Intake comment responses in RED below - Thanks! Chris, 9.15.21

<b>INTAKE COMMENTS</b> <b>CST</b>		Reviewer																															
		Email																															
		Status																															
		Intake #																															
<b>DATE</b>		<b>TIME</b>		<b>PERMIT #</b>																													
<b>Project Address</b>																																	
<b>Applicant</b>			<b>Owner</b>																														
<b>Scope of Work</b>																																	
CITY STAFF																																	
CUSTOMER SERVICE TEAM (CST)		LAND USE PLANNING (LUP)		BLDG PLANS EXAMINER (BLD)																													
FIRE REVIEWER (FIRE)		CIVIL, SITE, UTILITIES (CIVIL)		TREES (TREE)

### Average Building Elev. Calc.

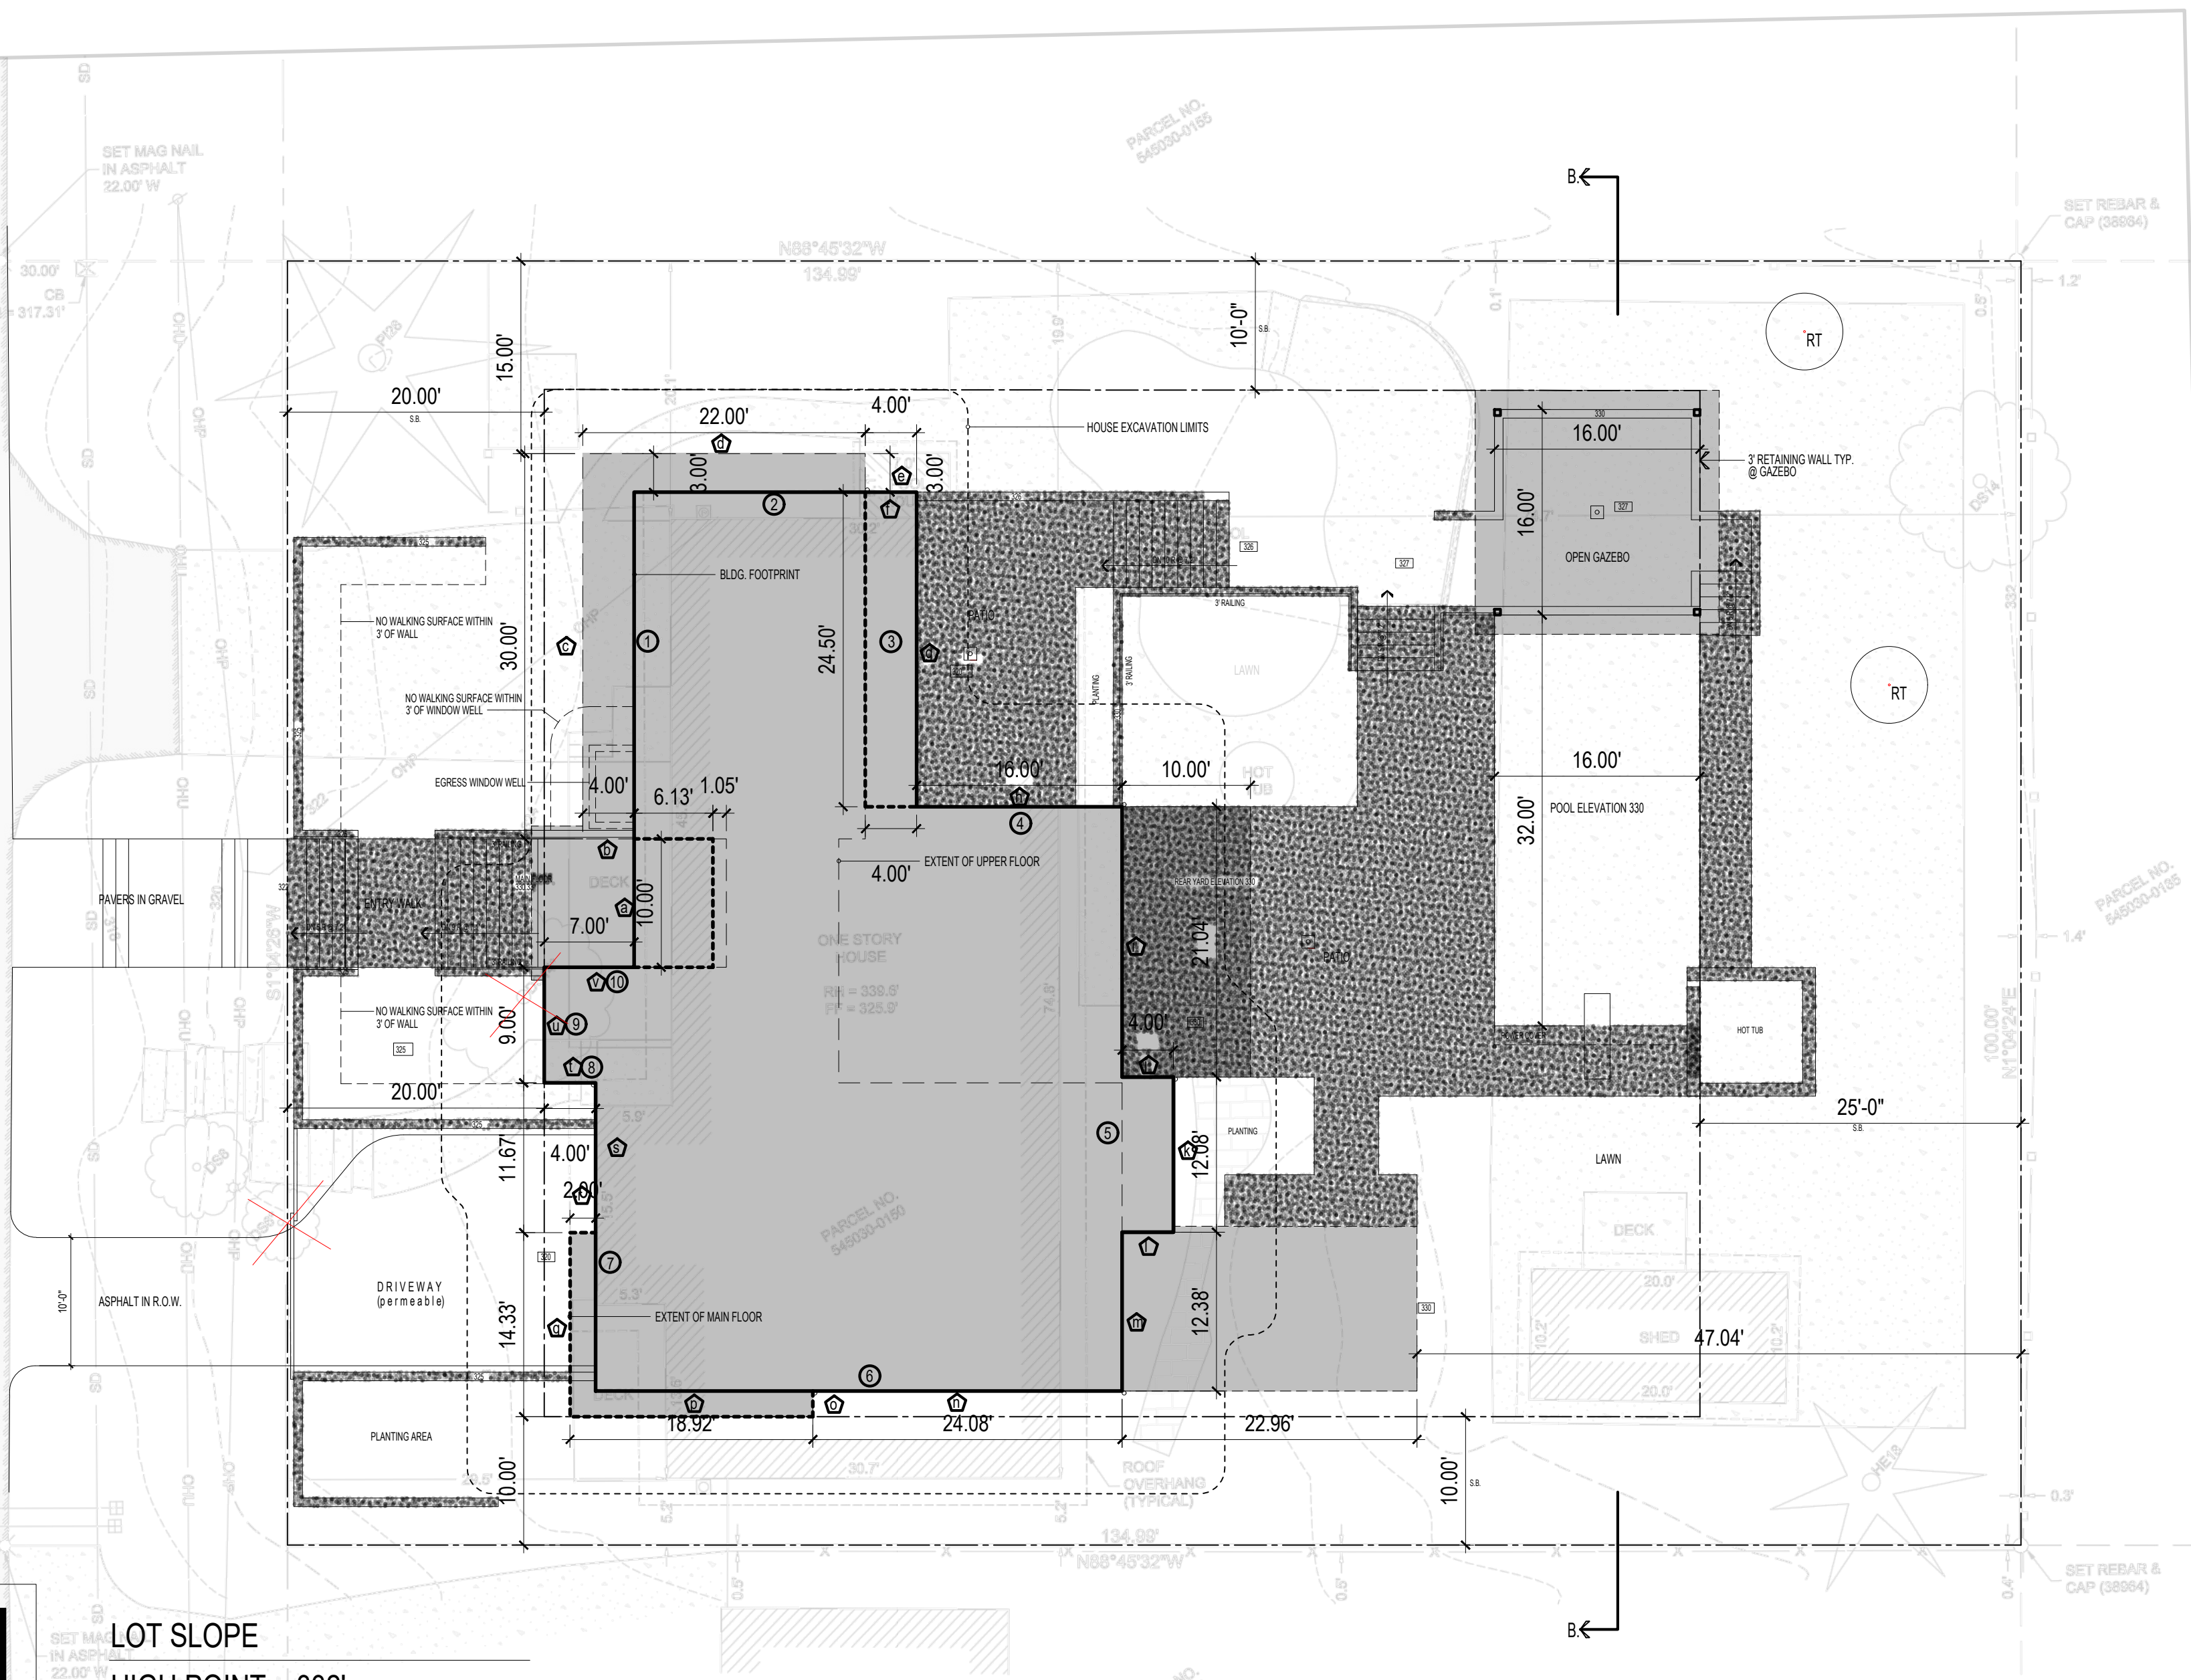
<input type="checkbox"/>	<b>Elevation Drawings</b>	
<input type="checkbox"/>	Indicate buildings and proposed height	
<input type="checkbox"/>	Indicate existing grade & finished grade	
<input type="checkbox"/>	Indicate Average Building Elevations (ABE) on all elevation drawings with ABE calculations	
<input type="checkbox"/>	Indicate maximum downhill building façade and height <b>added to elevations</b>	
<input type="checkbox"/>	Height of appurtenances above max height	
<input type="checkbox"/>	Indicate allowable building height on all elevation drawings	
<input type="checkbox"/>	Provide calculations for any basement areas being excluded from allowable gross floor area	
<input type="checkbox"/>	Indicate amount of grading (amount of cut and fill) outside the building footprint

Yes, elevations that are lower than exiting grade shown bolded and note added

I used the lower of existing or new in the calc. Bolded elevation numbers are those that are below existing grade - i will try to make the distinction clearer.
